Engineers Comments Regarding Surface Water Drainage

Application Reference:	P/110/25/DOC	Reviewer Reference:	ADC/Ext4
Planning Officer:	Simon Davis	Date of Review:	13/11/2025
Site Name:	Land West of Pagham Road Pagham Road Pagham PO21 3PY		
Application Description:	Approval of details reserved by condition imposed under reference P/178/21/OUT (APP/C3810/W/22/3302023) relating to condition number 11 - foul drainage system, condition number 12 - surface water drainage, condition number 13 - discharge rates of watercourses and condition number 14 - management and maintenance of surface water drainage system. (See P/109/25/DOC for condition number 17 - contamination, condition number 22 - internal noise level, condition number 24 - broadband provision, condition number 26 - bus stop information screens and condition number 28 - acoustic.).		
Assessment Number:	<u>24</u> of 2

Application Reference: P/110/25/DOC Site Name: Land West of Pagham Road Pagham Road Pagham PO21 3PY	Initial Issue Date: 13/11/2025 Issue Date: 13/11/2023 31/12/2025 Reviewer Reference: ADC/EXT4
--	--

ADC Drainage Comments	Designer Response	<u>ADC Drainage Comments</u>		
Date:	13/11/2025	5/12/2025	31/12/2025		
Con

scale 1:500	drawn by FA	checked by SL
date APRIL 2025	cad file CONTRIBUTING AREAS PLAN	
title CONTRIBUTING HARDSTANDING AREAS PLAN

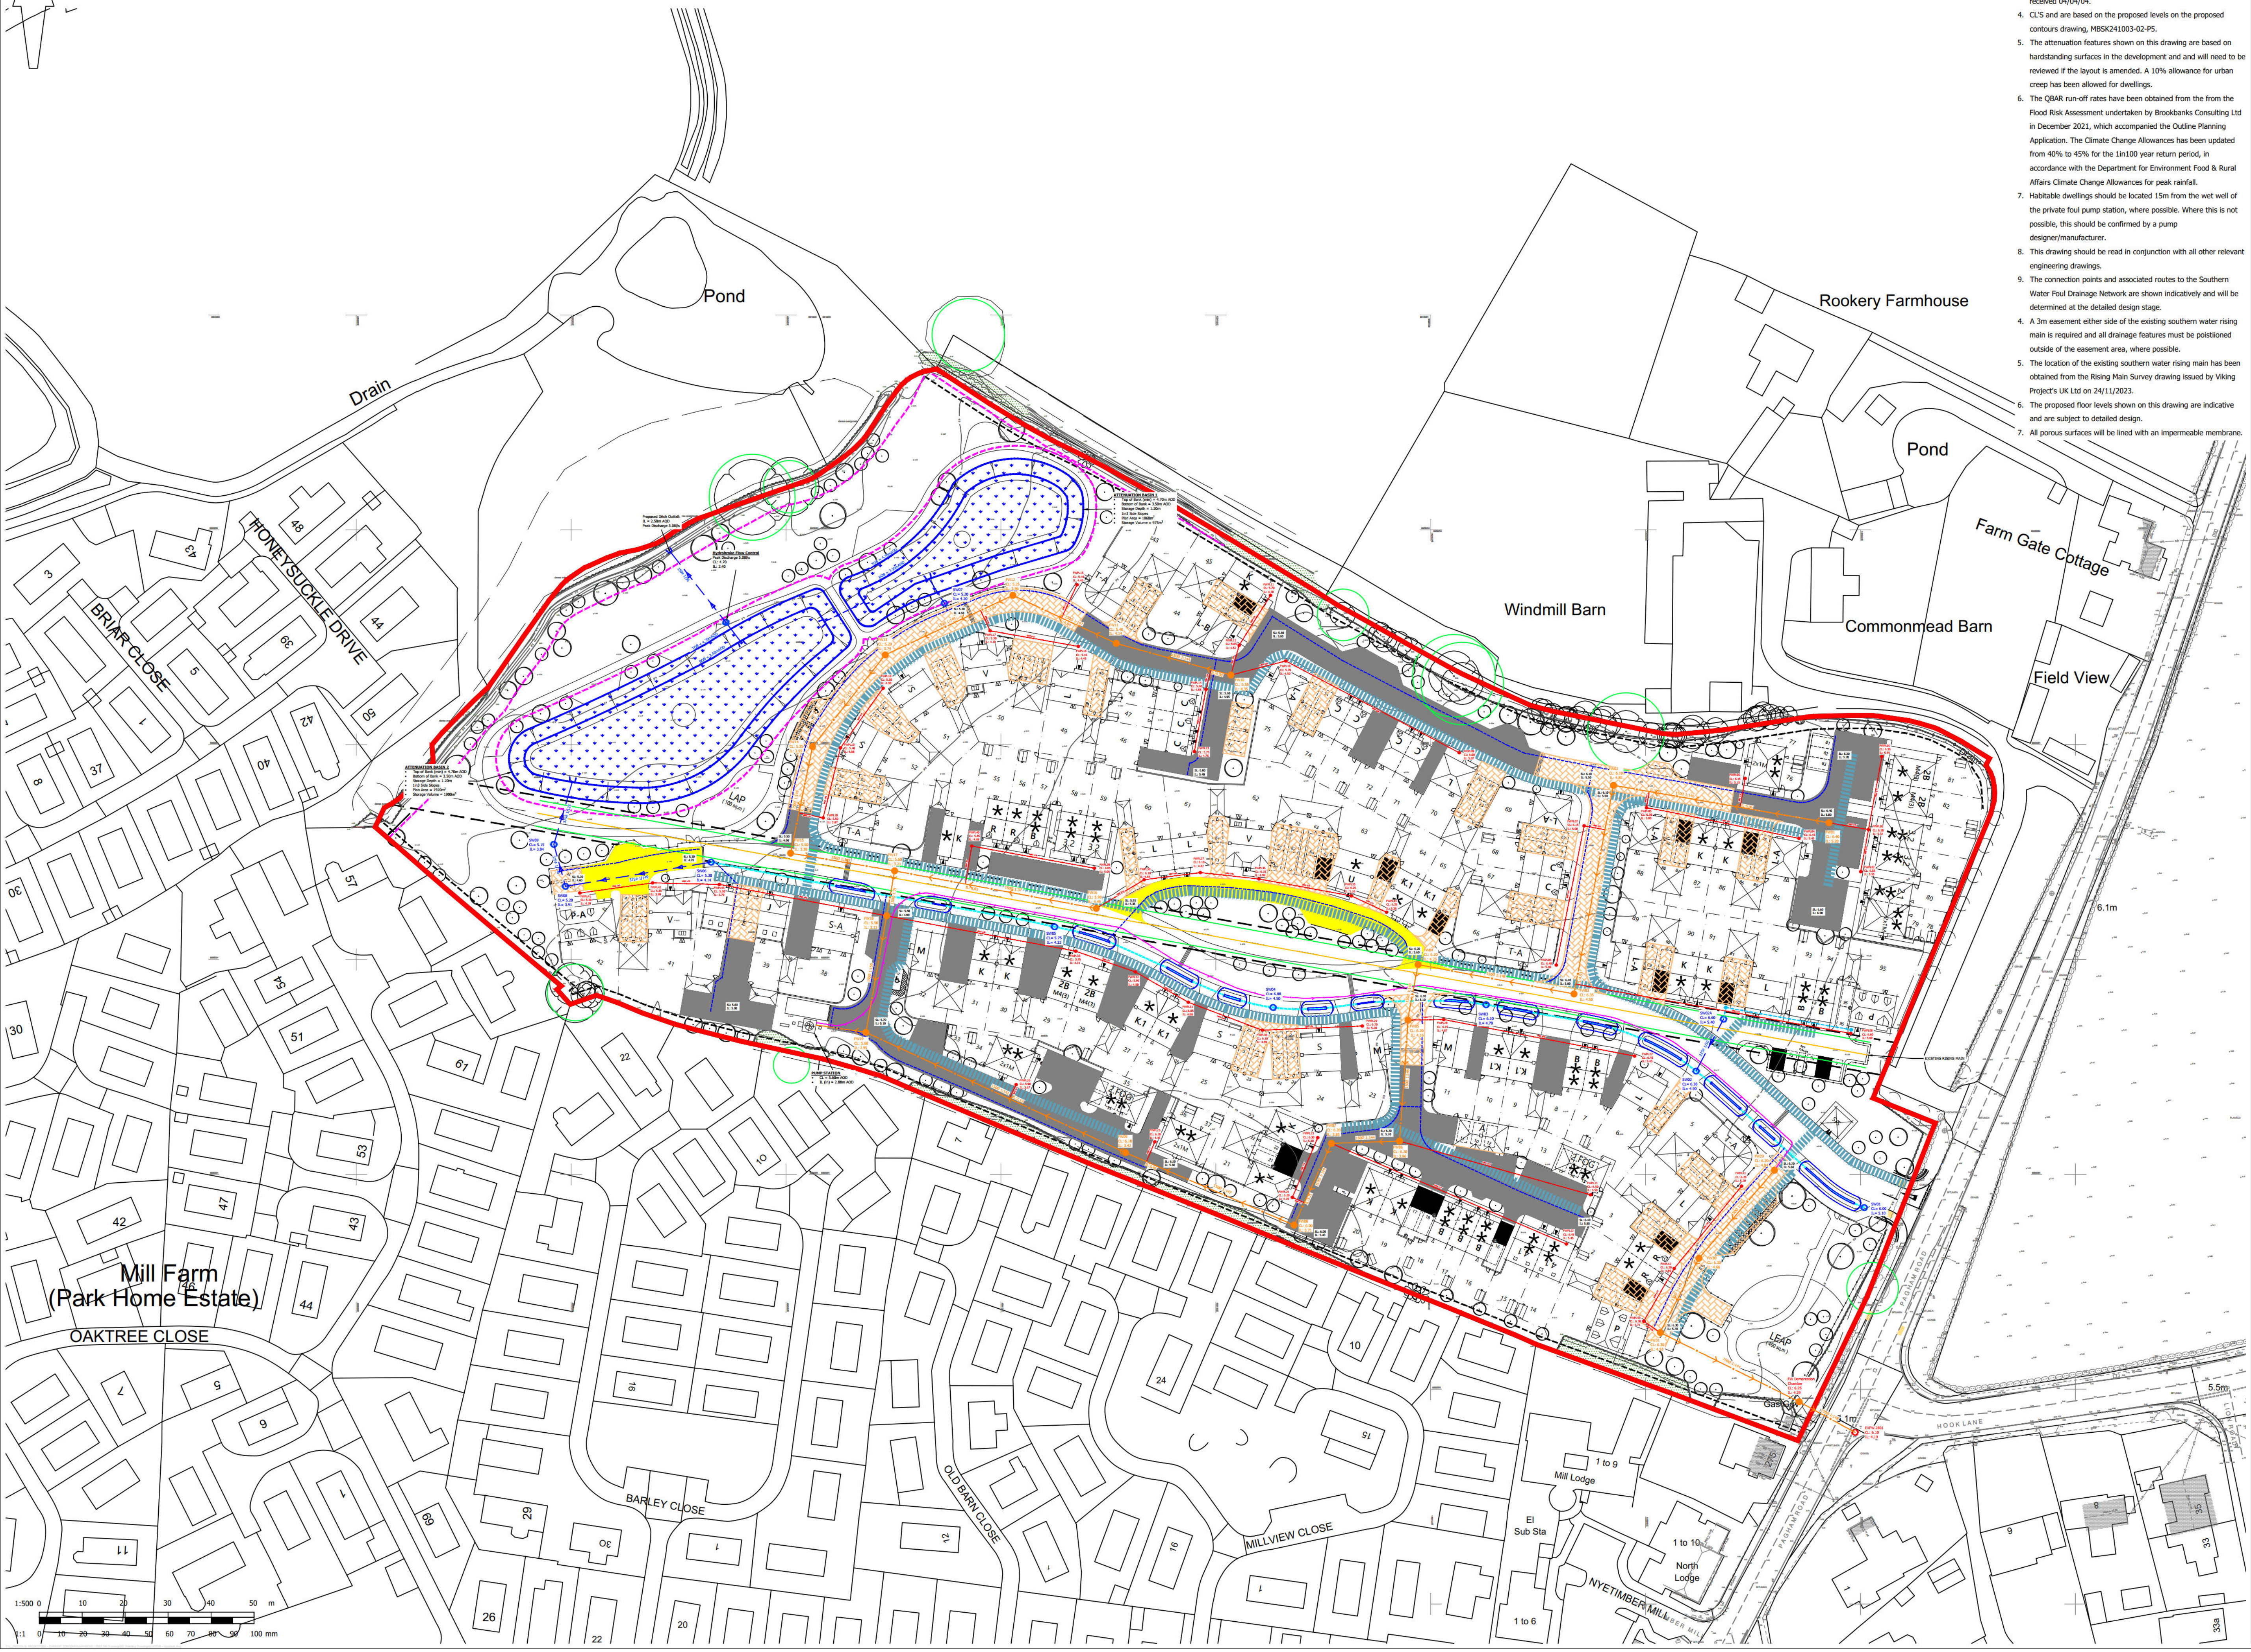
3.	Please provide further details on the contributing area catchment plan. Specifically provide a breakdown on which areas enter in specific pipes/manholes and making clear references to the pipe numbers/manholes on the plans and supporting calculations	<u>This is now included in Appendix G within the updated Technical Note.</u>	<u>Thank you item now closed</u>

TYPICAL CONVEYANCE SWALE SECTION

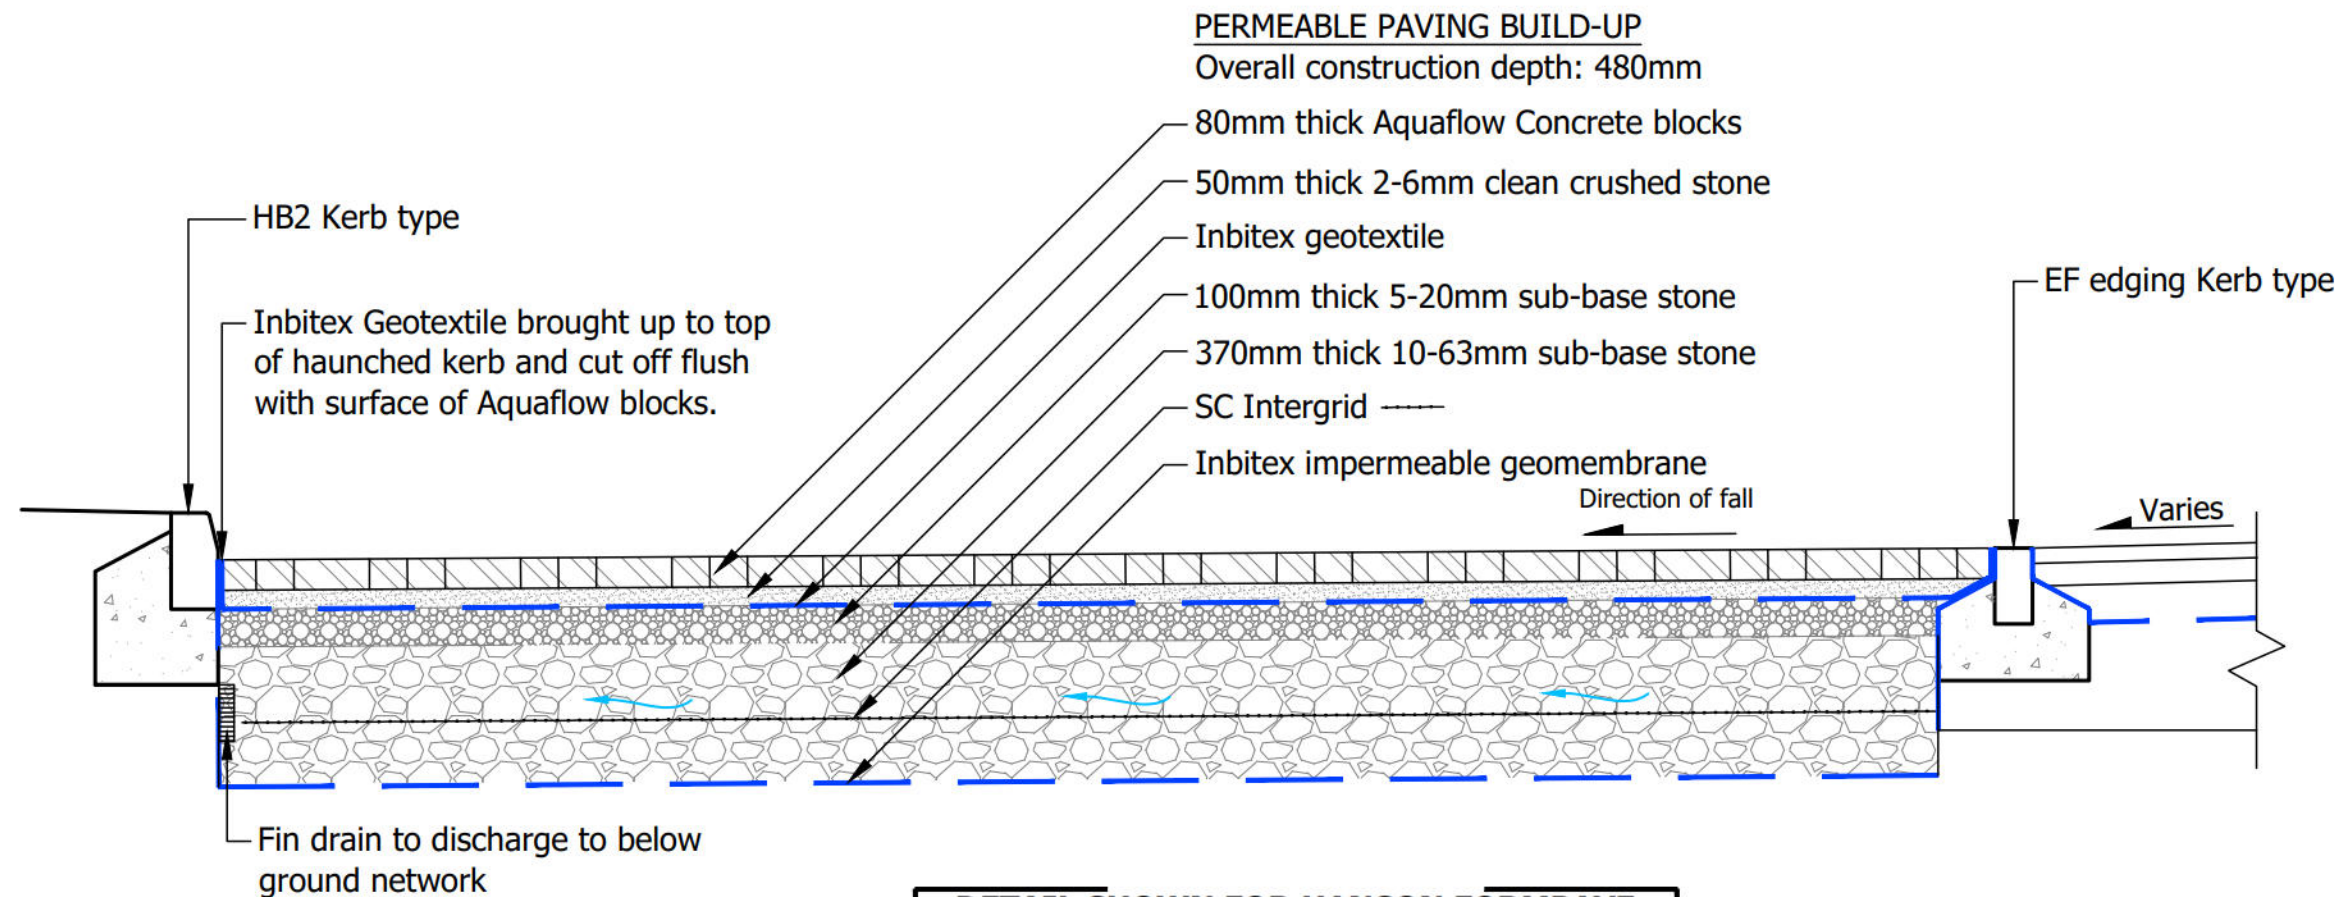
5.	The peak discharge from the site is proposed to be at the Qbar rate which the designers have based on the scheme at outline stage. The site layout and contributing area has changed since the outline scheme and the updated greenfield run-off calculations need to be provided reflective of the proposed schemes contributing area.	<u>In the Flood Risk Assessment that accompanied the Outline Planning Application, the QBAR greenfield runoff rates were calculated based on the following (refer to Page 27 of Appendix N in the Technical Note):</u> <u>Site Area = 4.91ha</u> <u>Developable Area = 2.95ha</u> <u>Impermeable Area = 55% (1.63 hectares+10% urban creep = 1.78 hectares)</u> <u>It should also be noted that the proposed calculations undertaken at the Outline Planning Stage included a climate change allowance of 40%</u> <u>The greenfield runoff rates were therefore</u>	<u>Thank you for providing the clarification. Item now closed</u>

to be missing from the submission	<u>manhole schedules are now provided in Appendix S within the updated Technical Note.</u>	<u>permeable drives which appear to drain to the same conveyance swale filter drain alongside the main impermeable road. We have concerns that where the swales and sections of filter drain (where passing under swales) are unlined that the shallow groundwater could enter the proposed surface water and attenuation system. Please provide section details on all highway swale, clearly providing details on invert depths, associated filter drain depth etc... Each swale should have its own specific construction detail to ensure they are installed in accordance with the design drawings Please provide further details on the site wide permeable paving arrangement, currently its unclear whether an arrangement of check dams with throttle pipes are being proposed, which seems to be proposed in the calculations but not</u>

clear on the plans. Can we suggest providing a clear plan of the site wide permeable paving arrangement clearing indicating the sections referred to in the calculations with associated link pipes or controls and their interface to the main conveyance drain.

BAGWORK HEADWALL CROSS SECTION

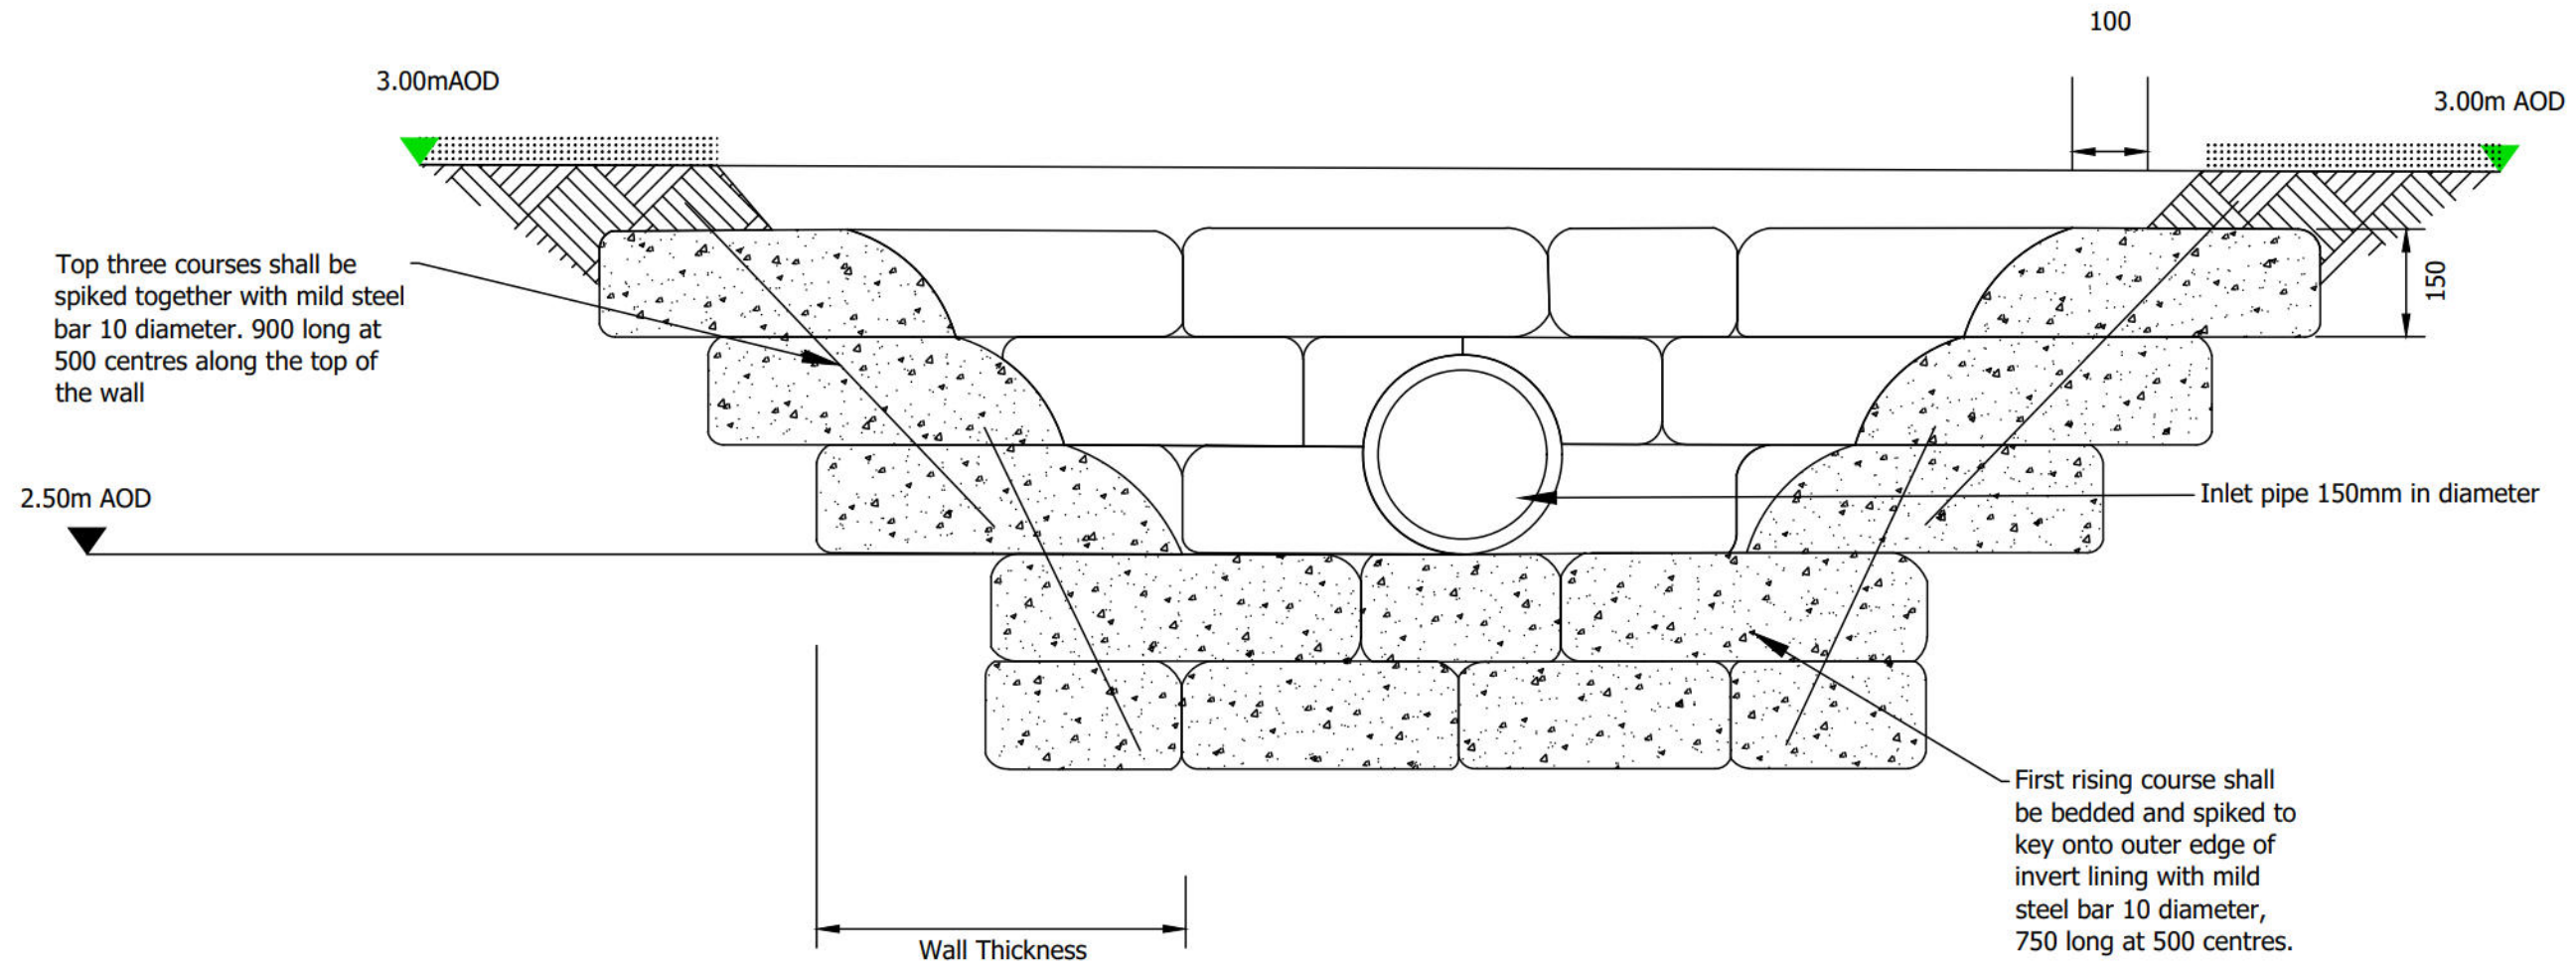
12.	The drainage details need to be provided at construction detail level. The current	<u>The construction drainage details are now</u>	<u>Please provide details of the outfall headwall to the existing ditch</u>
